**NorthConnex Application Number: SSI 13\_6136**

Please find below my/our submission in response to the exhibition of the EIS for NorthConnex.

M1-M2-5000-DR-JD-0550  
NORTHERN VENTILATION FACILITY - CROSS SECTIONS

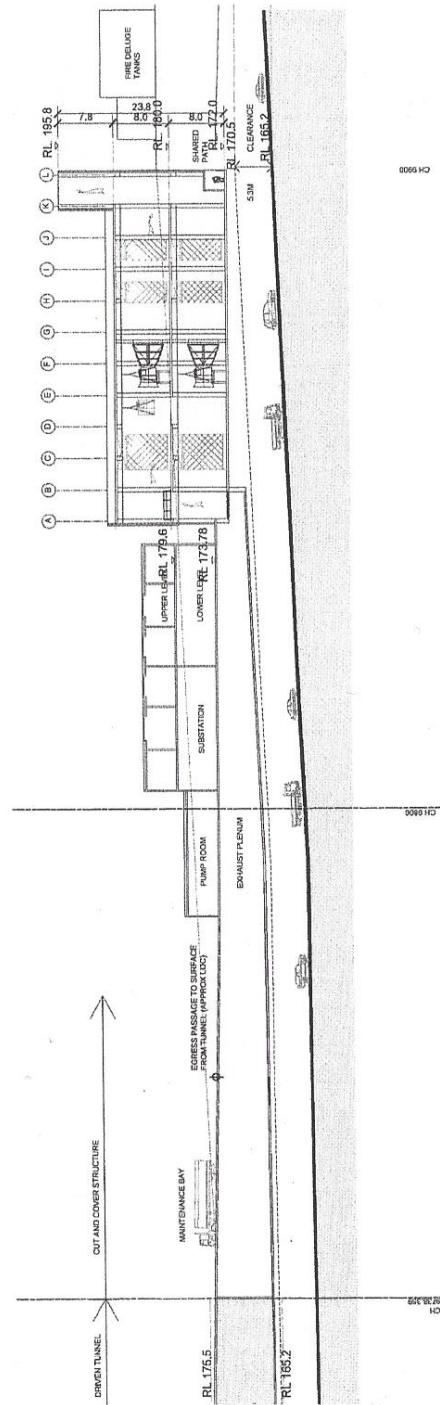
The placement of the northern ventilation stack is in a valley.

When located in a valley such as is proposed for the northern stack, the ventilation stack will increase deposition of particulate matter in the immediate surrounds, as there is less dispersion effect from a stack when placed in a valley.

The current stack is only 15m high, located in a valley, therefore, for 9km tunnel this is too low to enable the pollution to push through an inversion layer. It is in a valley with houses further up the road being equal in height to the top of the ventilation stack.

*Locate the northern ventilation stack on higher ground.*

*Increase the height of the stack to at least 70m to enable effective dispersion.*
